## City of Albuquerque

March 15, 1984

RE: DRAINAGE PLAN FOR ADDITION TO ALBUQUERQUE DERMATOLOGY ASSOCIATES  
(J15-D18)

Site Plan

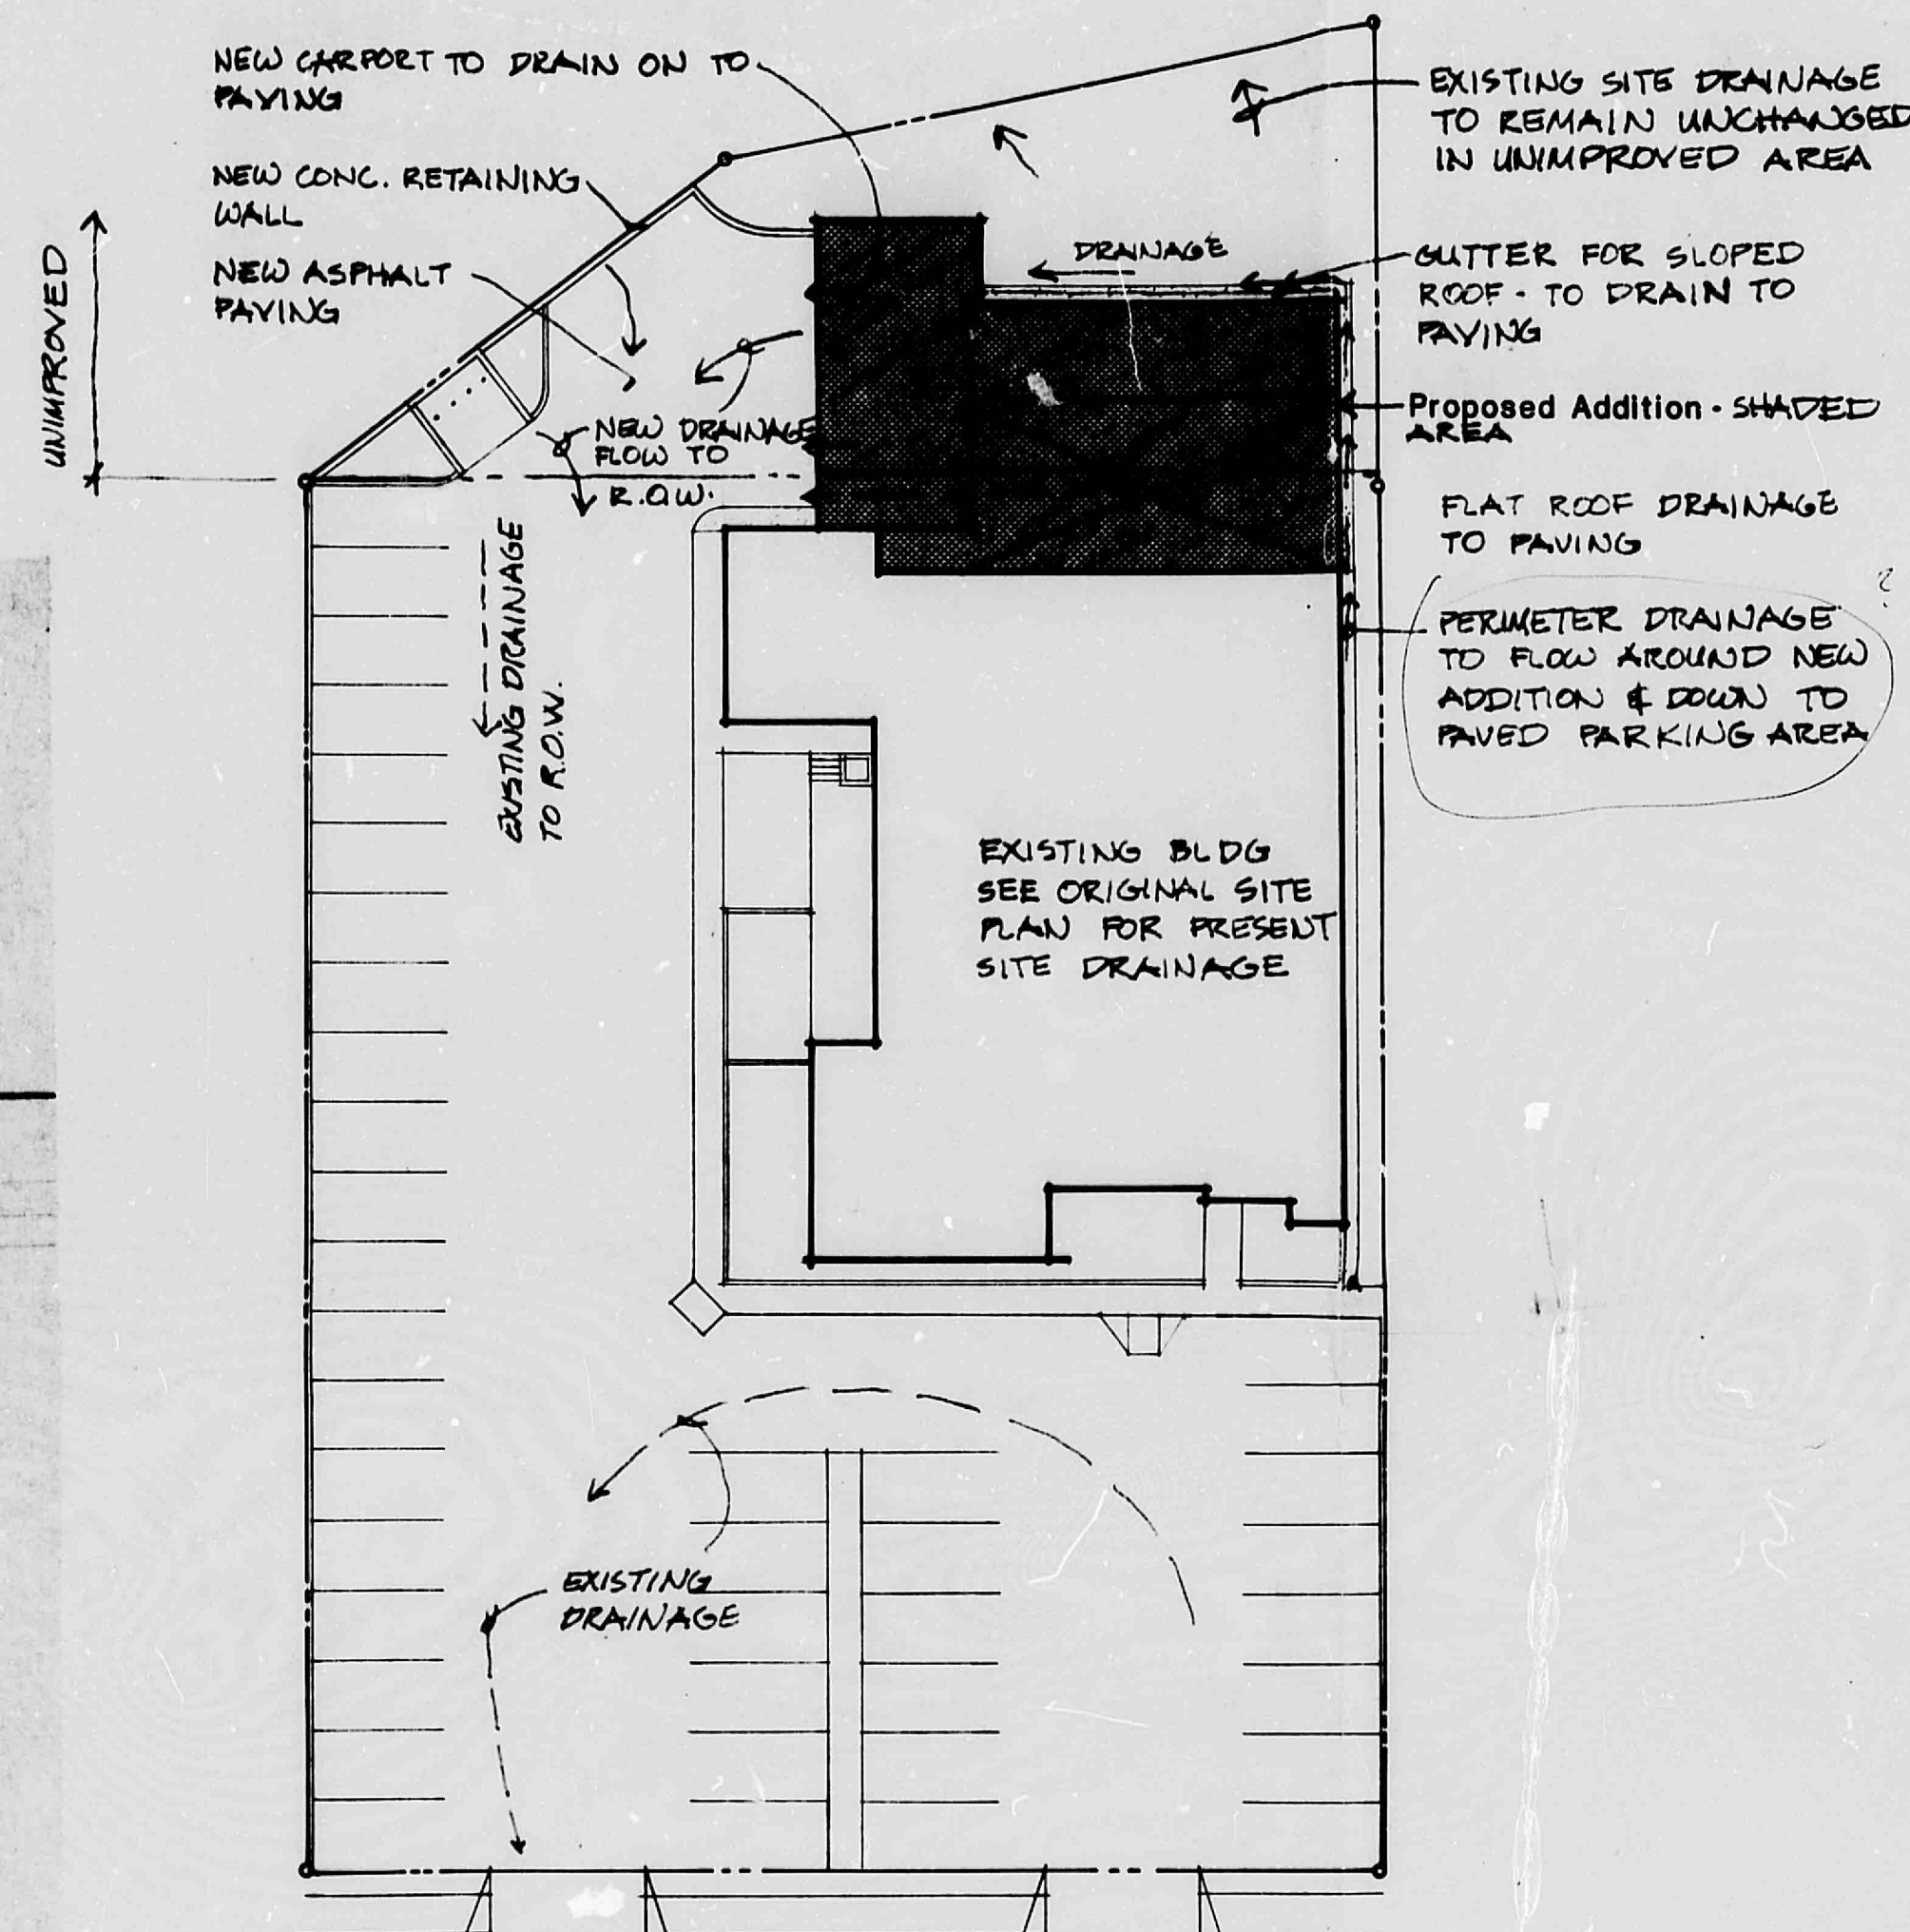
<sup>location</sup>  
Currently Site is draining into Fords Parking Lot. Site drops off about 6' and retaining wall will have to be built. Plus Plans indicate wall would need to be removed.

Engineer to submit a drainage Plan addressing Flow into Ford and retaining wall
